Our Ref: ID 3576
Your Ref: SSD-83258708

State Significant Development Application for EIS Florida Street, Sylvania, Affordable Housing SSD-83258708

Thank you for the opportunity to provide advice on the State Significant Development Application for 29 Florida Street, Sylvania. It is understood that the proposed development undertaken by Homes NSW consists of both social and market housing and seeks to construct eight residential buildings with a total of 484 dwellings, completed in 2 stages comprising:

Map 8 - PMF - Existing Scenario - Flood Hazard

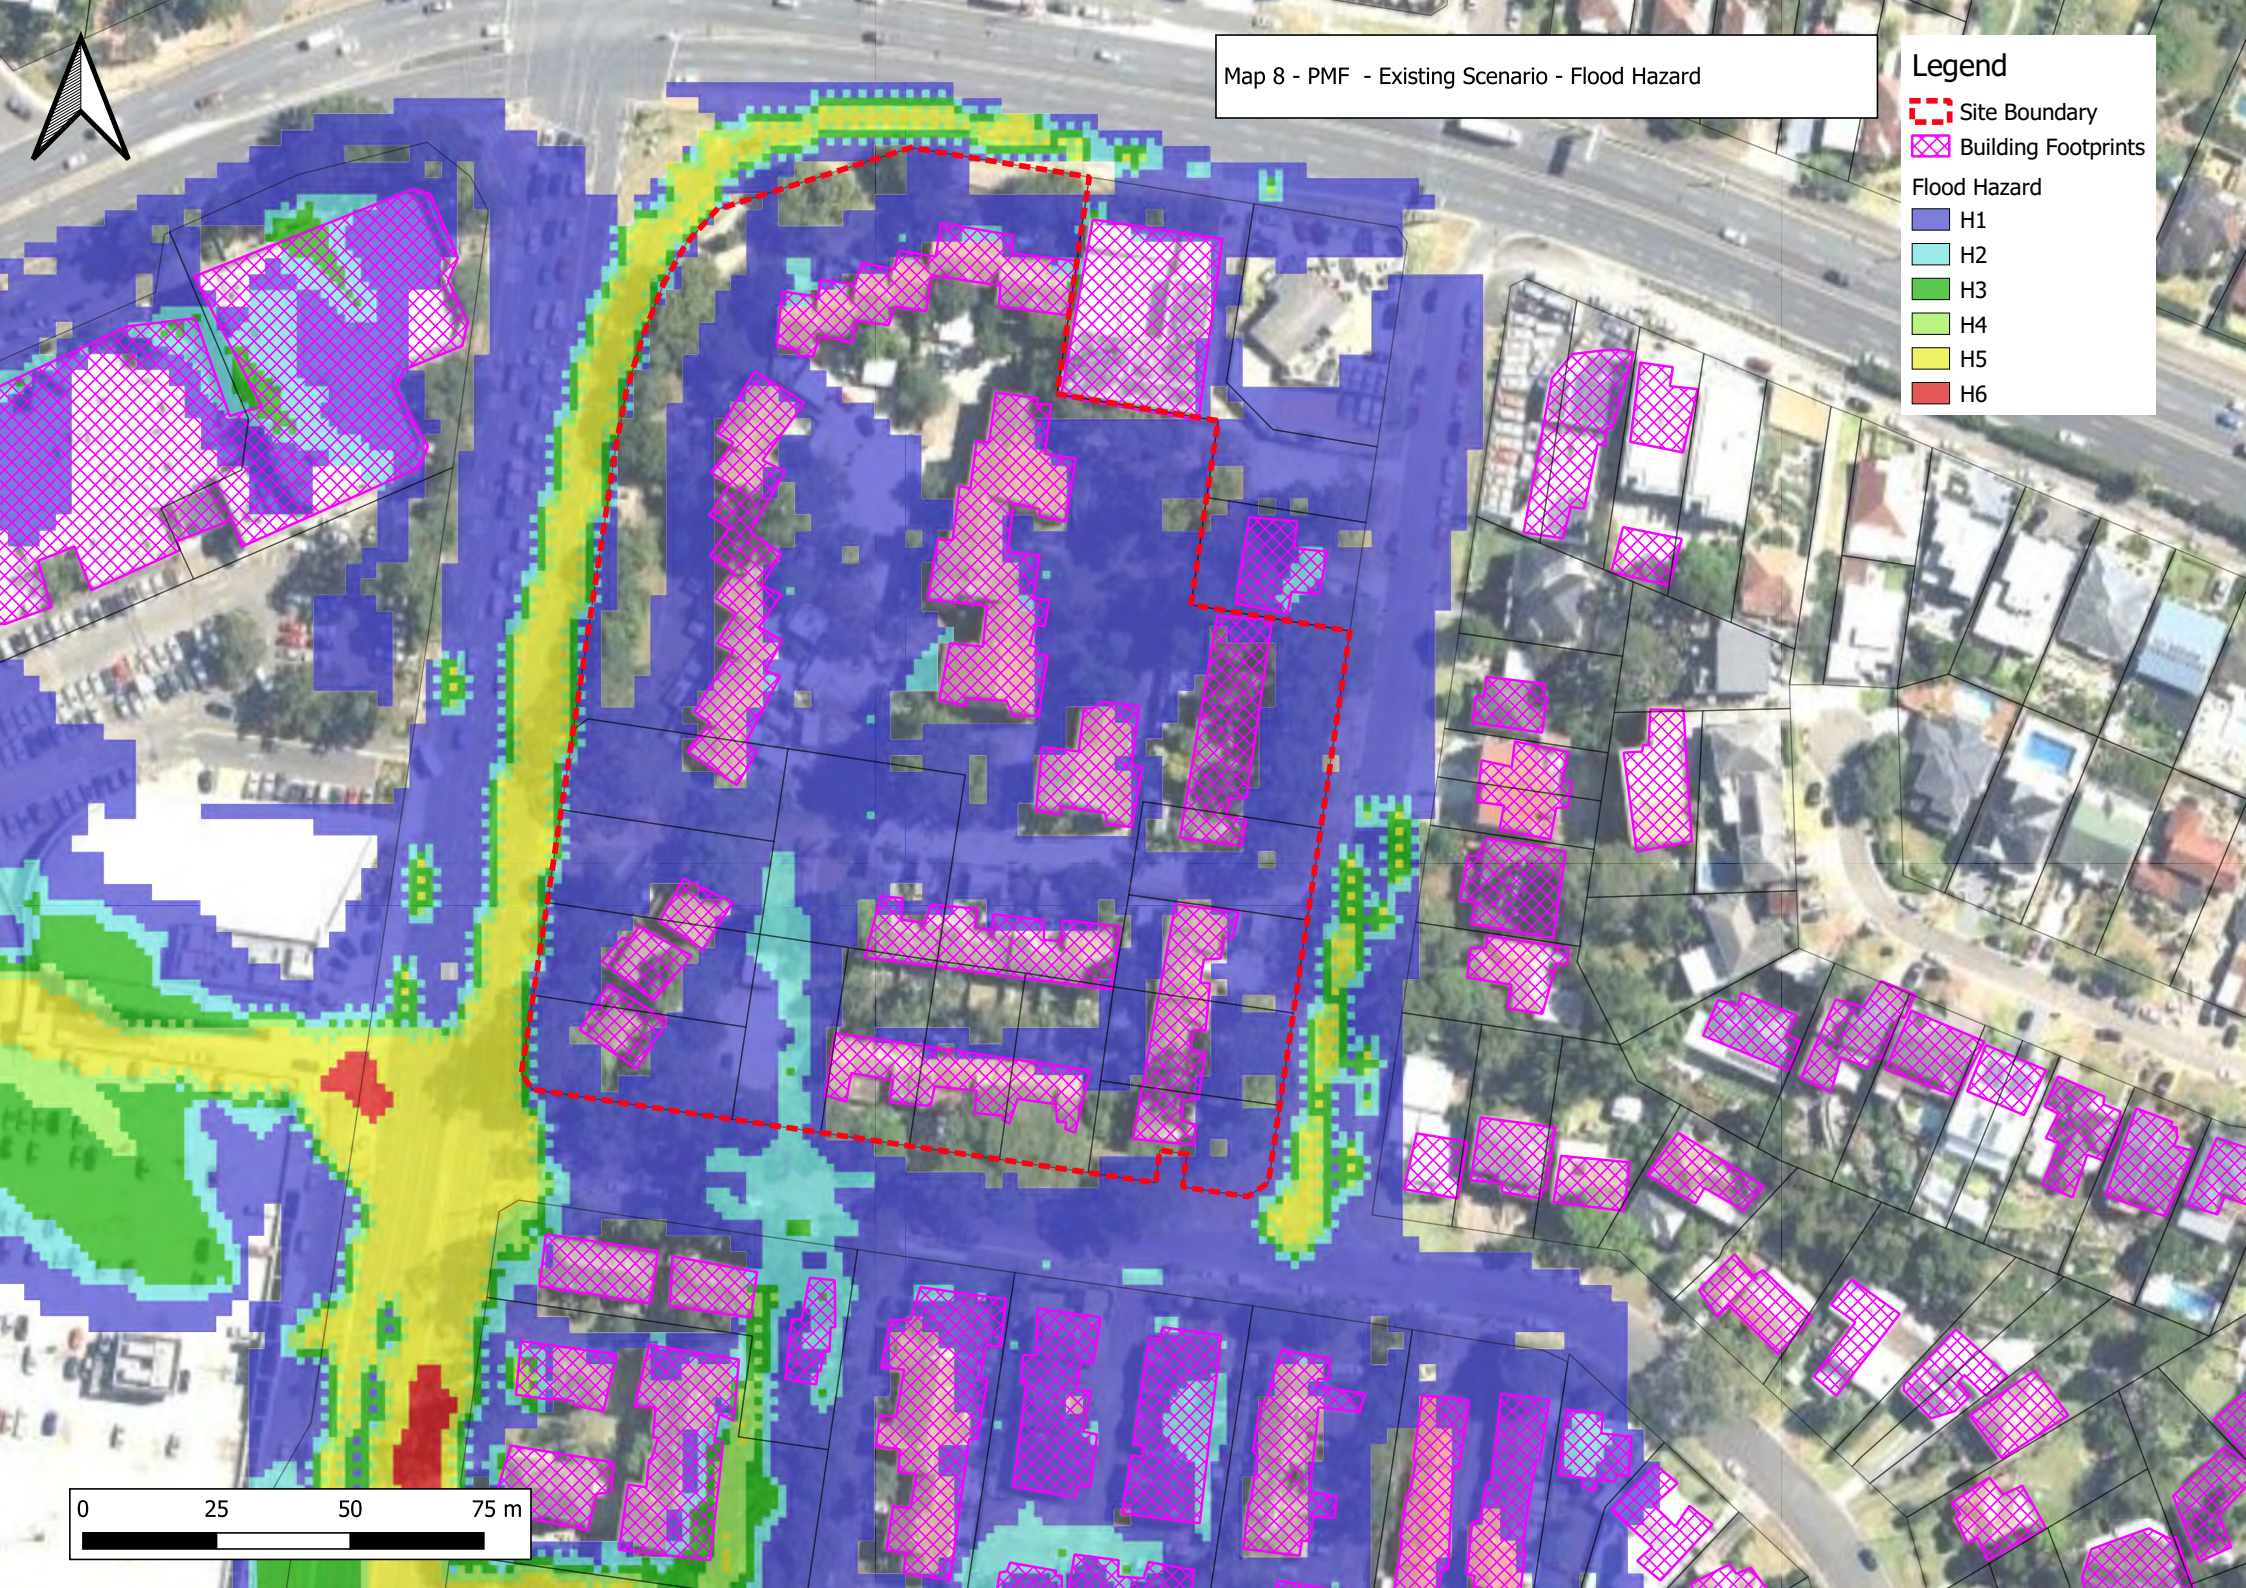
The site is affected by shallow overland flow as frequently as the 20% Annual Exceedance Probability (AEP) event.¹ During the PMF event, under current conditions, the site is largely inundated reaching depths of up to 0.5 metres² and Hazard Level 2 (H2).³ The level of hazard on roads surrounding the site is significantly higher, reaching H5. This level of hazard is unsafe for all people and vehicles with buildings requiring special engineering design and construction.

special engineering design and construction. During the PMF event under existing conditions flooding within the site is limited to H2,¹⁶ which is unsafe for small vehicles, while under proposed conditions it contains a H5 flow path through the site.¹⁷

This increase in hazard within the site, as well as the existing high hazard of surrounding roads is inconsistent with the [Shelter-in-Place Guideline](#) (NSW Government, 2024). The consent authority should request the proponent to demonstrate consistency with the Shelter-in-Place Guideline prior to granting consent, to ensure the risk to life is adequately managed and/or mitigated. This includes addressing consideration 8c. development is not subject to high hazard flooding or surrounding roadways are not subject to high hazard flooding. Applying a shelter-in-place strategy to new development surrounded by high hazard flooding poses a risk to life to site users who may attempt to leave or re-enter the site if they become trapped outside the site during flood events.

Map 10 - 20% AEP - Design Scenario - Flood Hazard

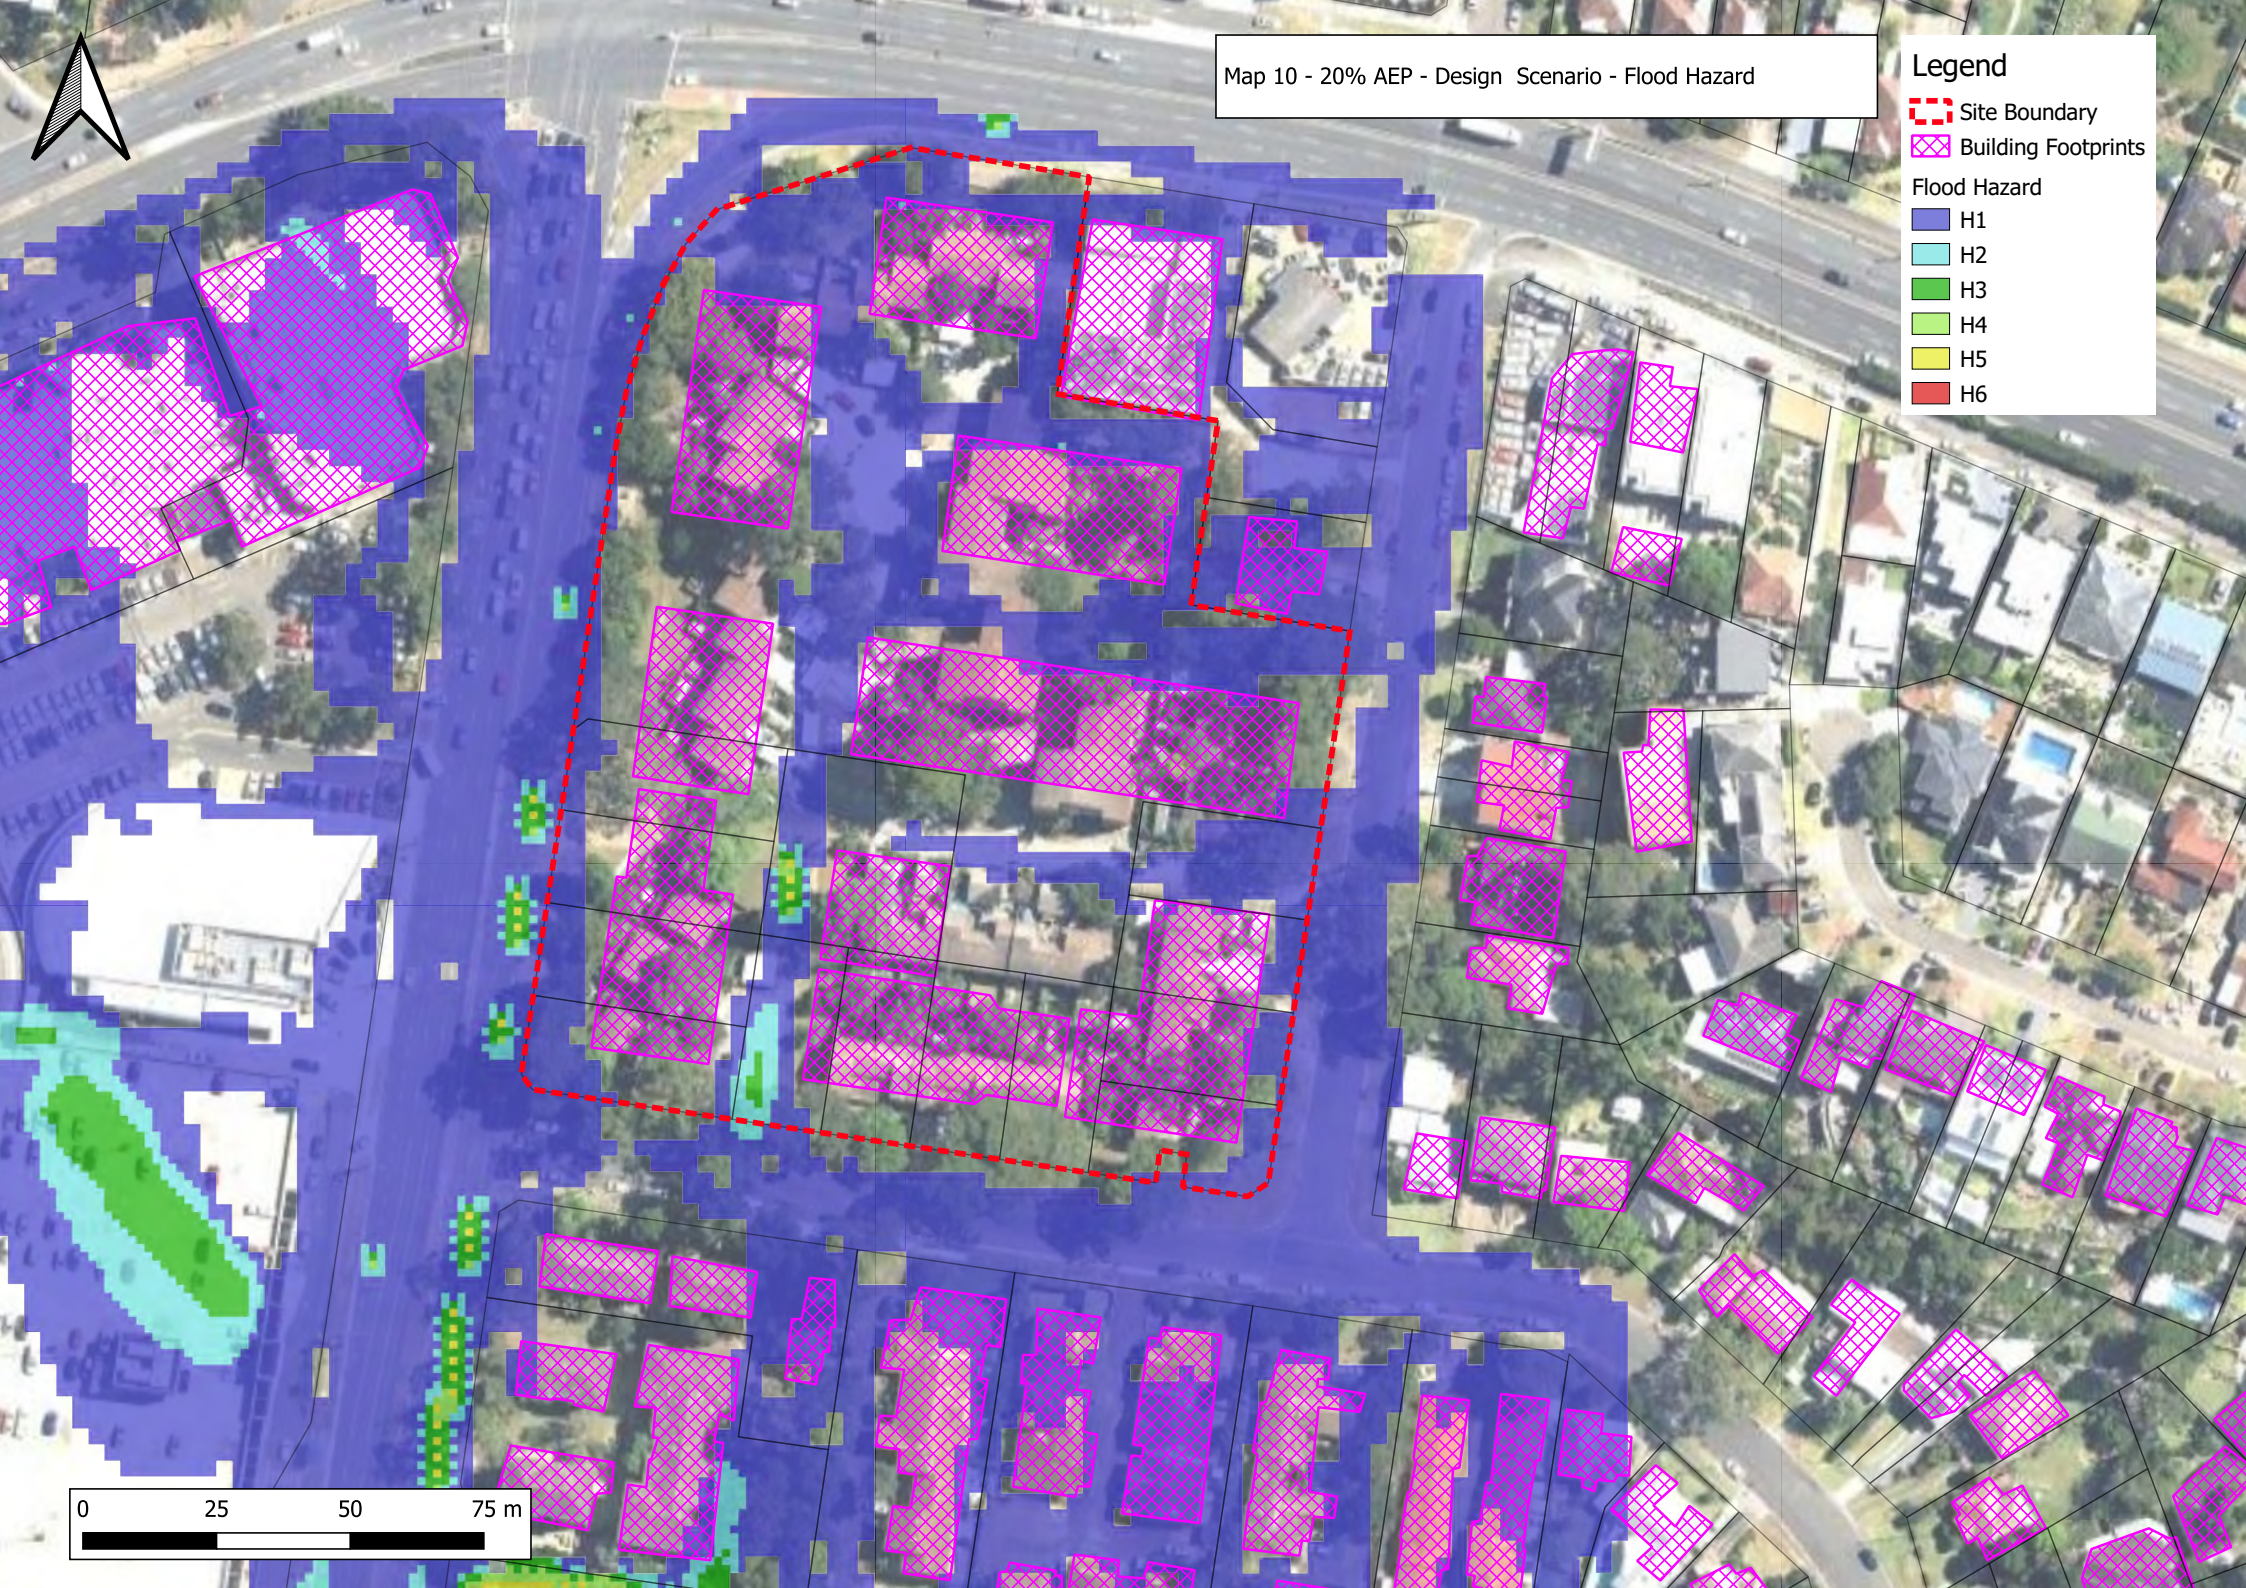
- **The proposed design increases flood hazard within the site posing a risk to life to site users.** By including the proposed mitigation measure of *"the channelisation of overland flows within the Site to the internal roadway"*⁴ the hazard within the site itself is increased in all flood events from the 20% AEP flood,⁵ with flooding within the site during the PMF increasing from H2 to H5.⁶
- **The proposal has not demonstrated consistency with the [Shelter-in-Place Guideline](#)** (NSW Government, 2024). The consent authority should request the proponent to demonstrate consistency with the Shelter-in-Place Guideline prior to granting

The proposed design increases flood hazard within the site posing a risk to life to site users. By including the proposed mitigation measure of *“the channelisation of overland flows within the Site to the internal roadway”*¹³ the hazard within the site itself is increased. During flood events up to and including the 1% AEP flood the hazard is increased from H1,¹⁴ which is generally considered safe, to contain *“A peak flood hazard of H5 within the internal proposed roadway.”*¹⁵ This level of hazard is unsafe for all people and vehicles with buildings requiring
